Re: Addendum Letter
398, 402, 406 Roosevelt Avenue, Ottawa
GW File No.: 17-179-Addendum Letter

Gradient Wind Engineering Inc. (Gradient Wind) was retained by ML Westboro Inc. to undertake a traffic noise assessment for the proposed six storey mixed-use condominium development located at 398, 402, and 406 Roosevelt Avenue in Ottawa, Ontario, for which Gradient Wind prepared a Traffic Noise Assessment report (ref. GWE17-179 – Noise Final R1, dated March 29, 2018).

This letter is to address recent site plan changes noted in the updated drawing set received from RLA Architecture, dated April 1, 2022, as well as to address City of Ottawa comments on our original report. The numbered comments along with Gradient Wind's response to each comment are as follows:

SCALE:	SHEET No:
1 : 125	A-200

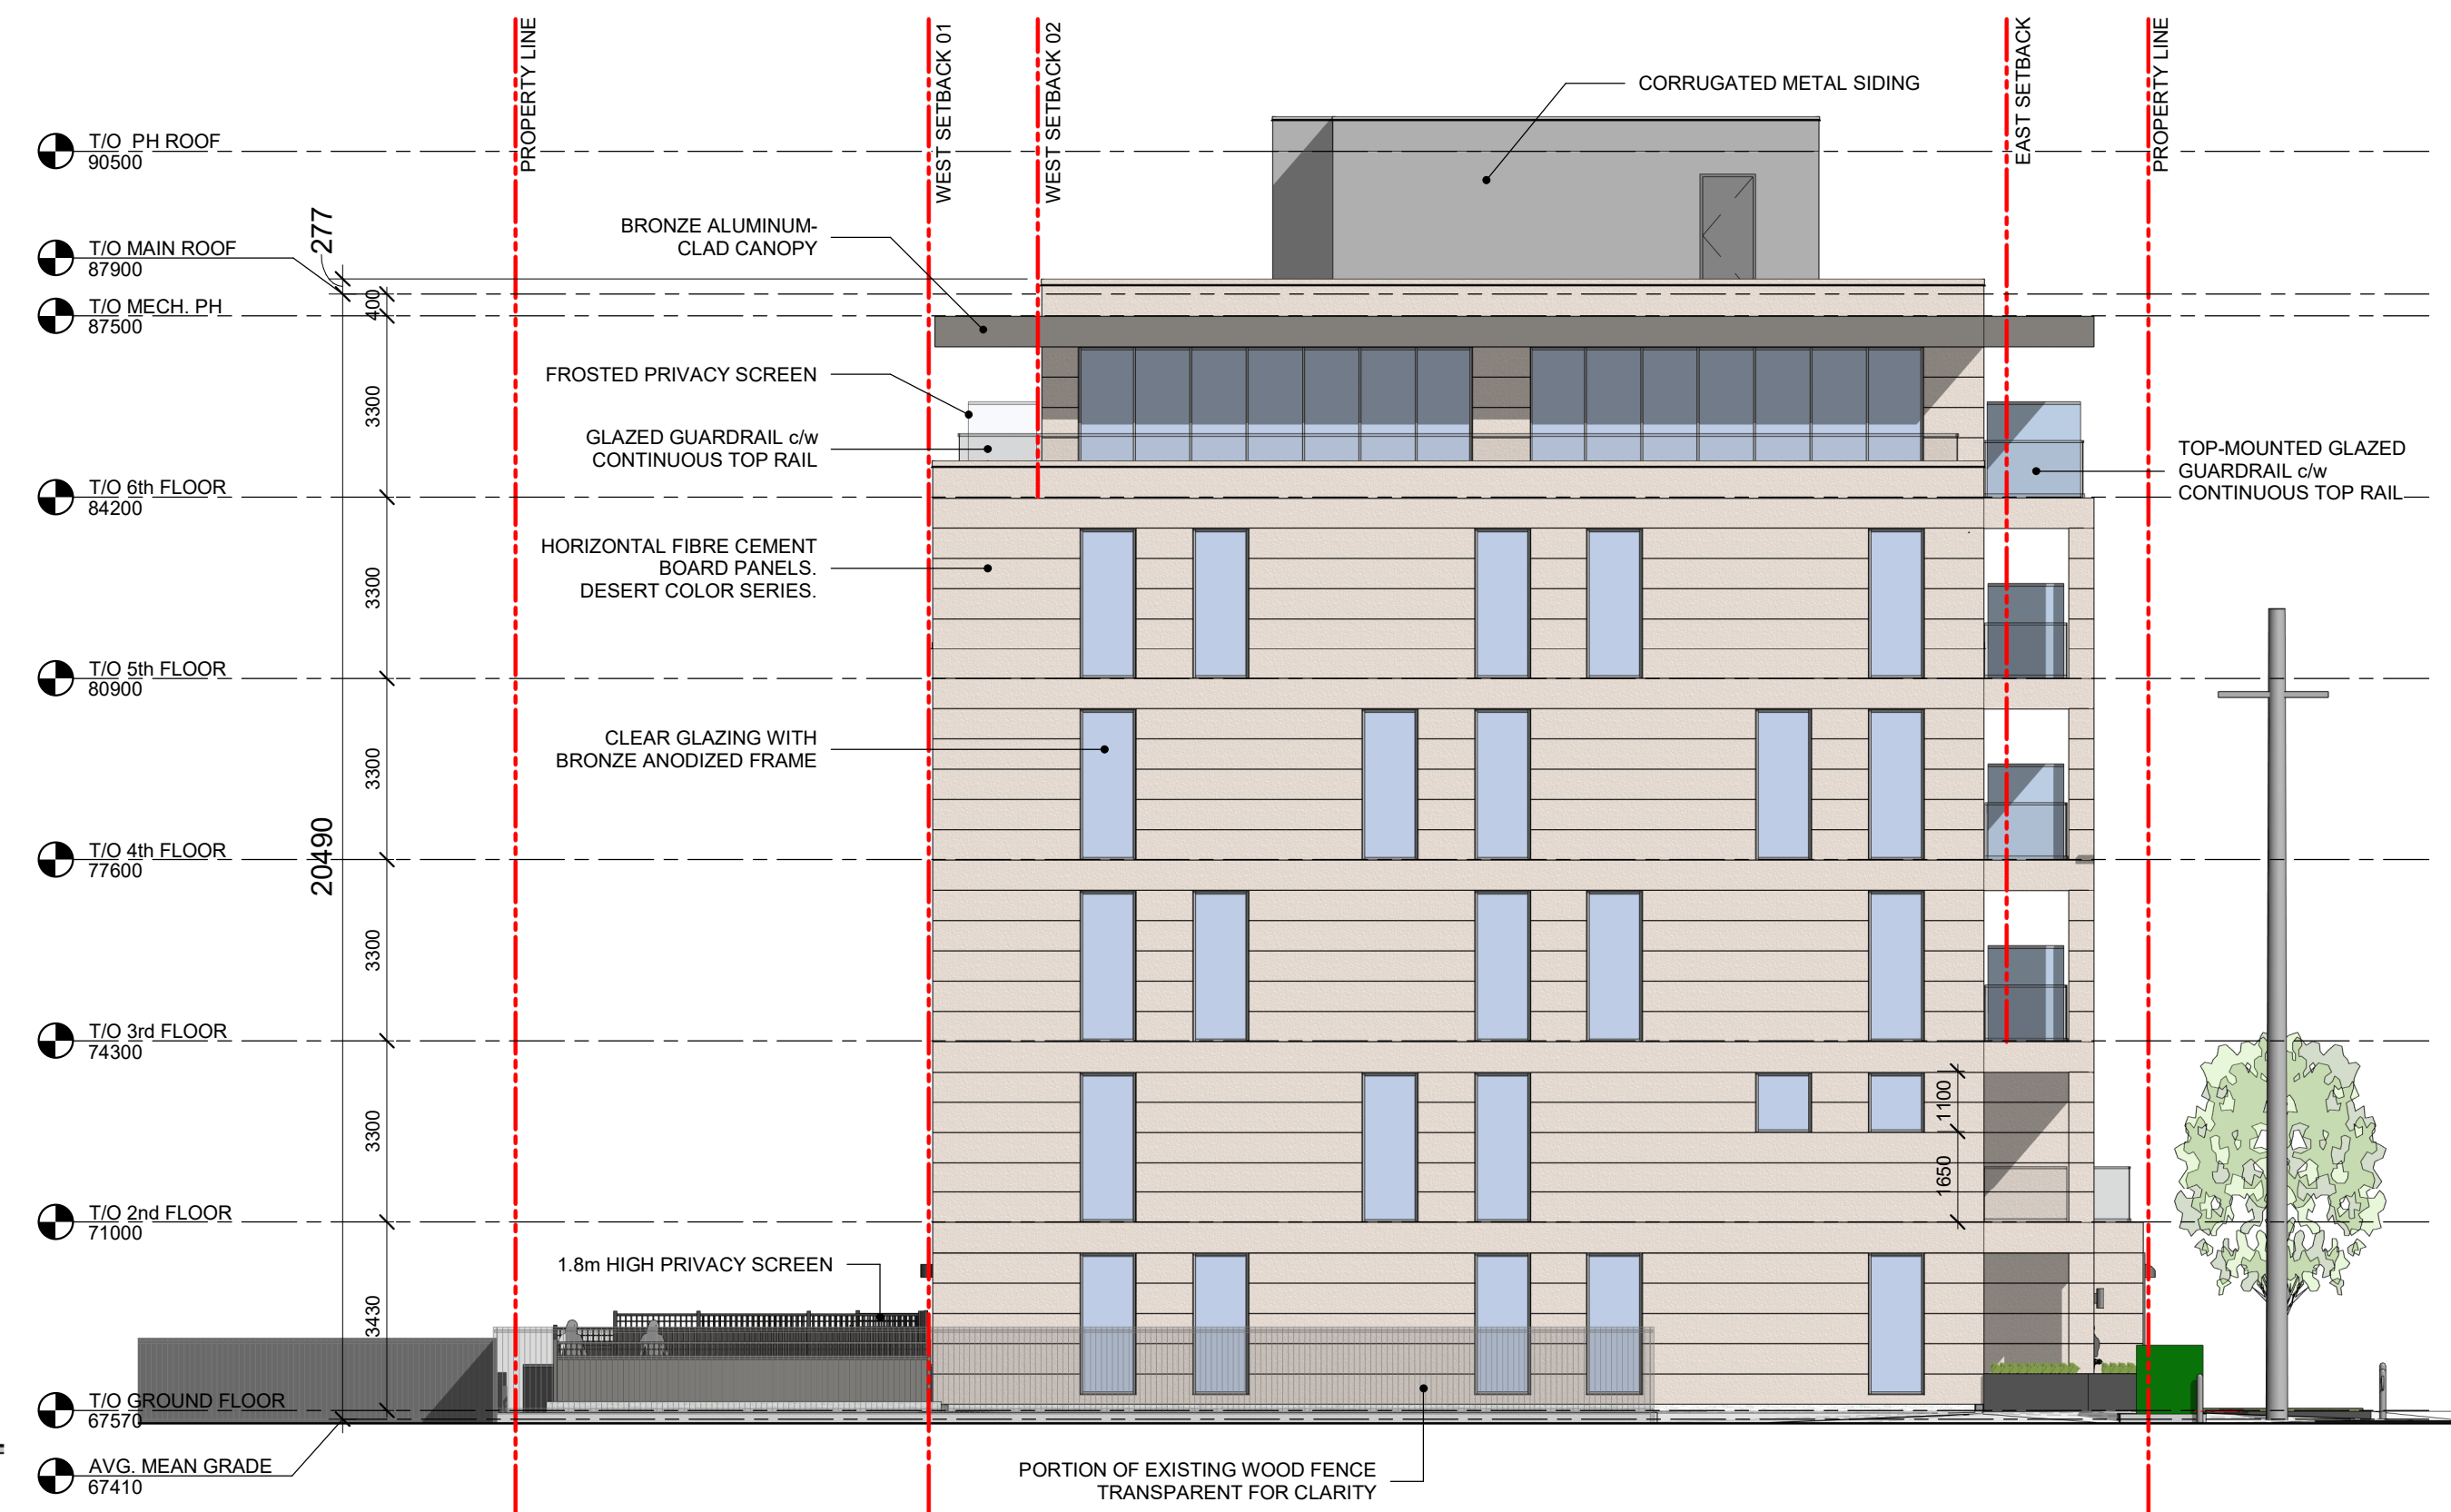
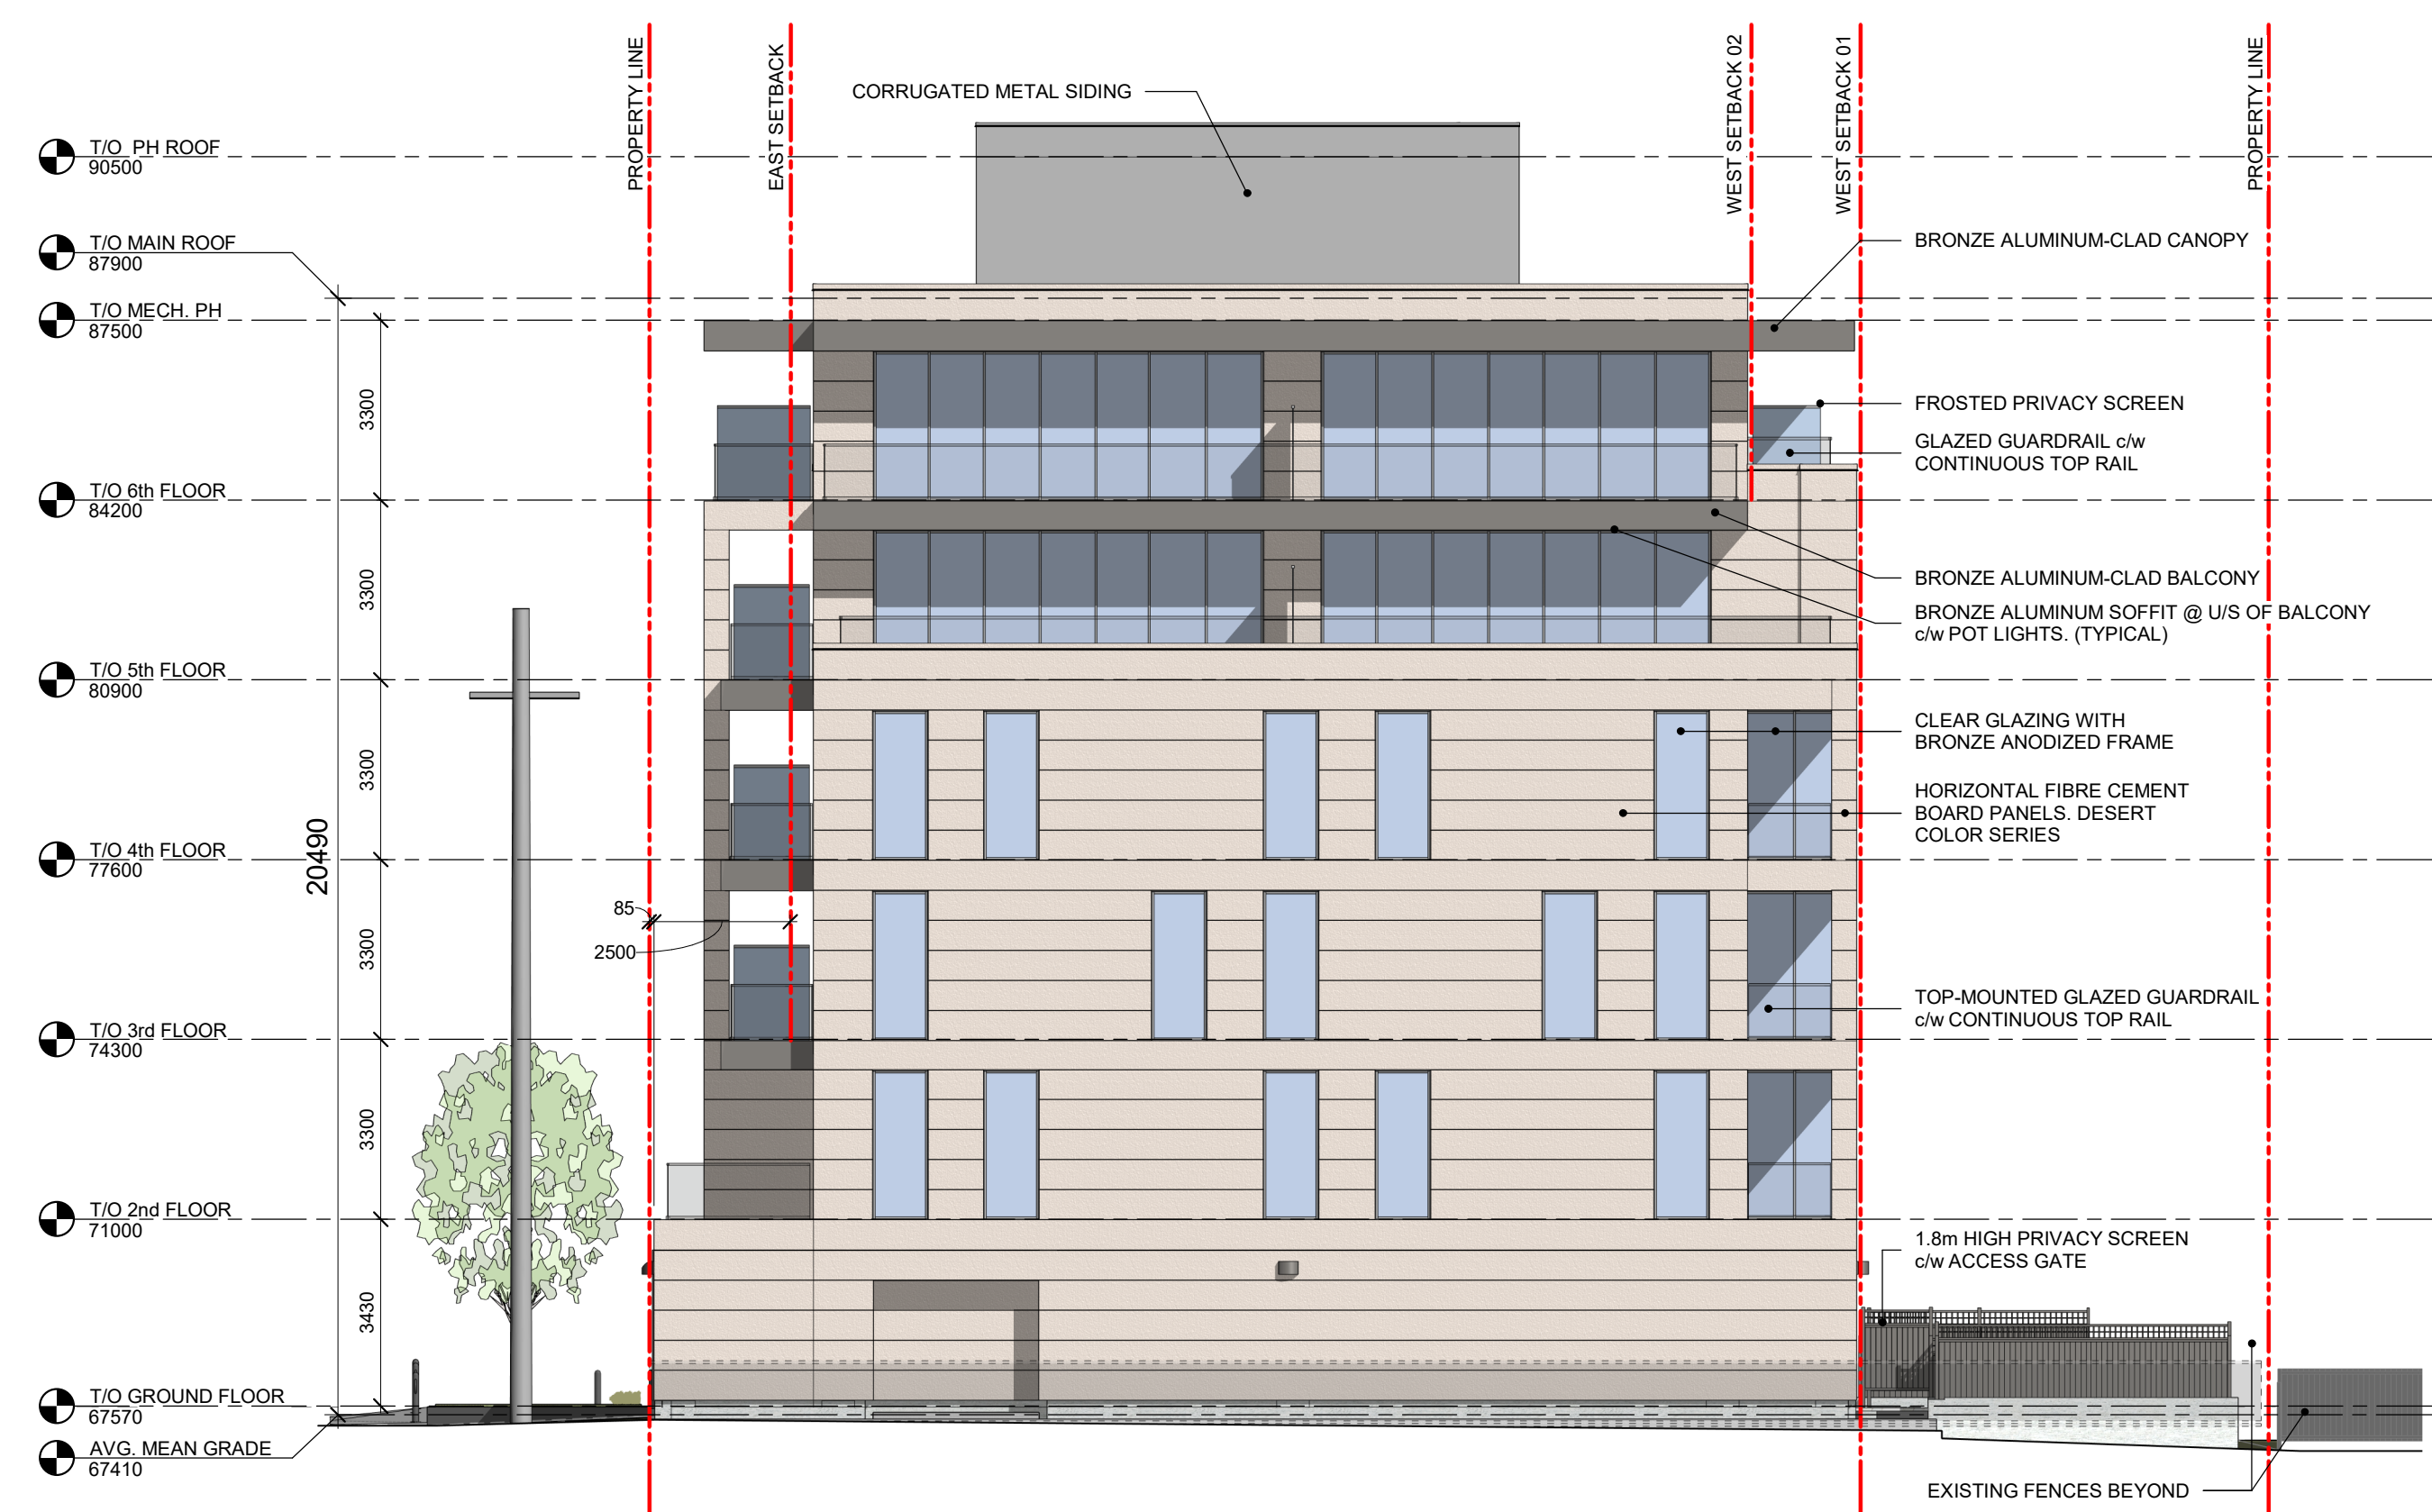
City of Ottawa: *Report is from 2018 and is out of date.*

Gradient Wind: It is noted that the massing and building height in the latest drawing set remains largely unchanged compared to the 2018 report. From an acoustic perspective, the changes outlined in the drawings are considered minor and are expected to have a negligible impact on the results and conclusions summarized in our Traffic Noise Assessment report.
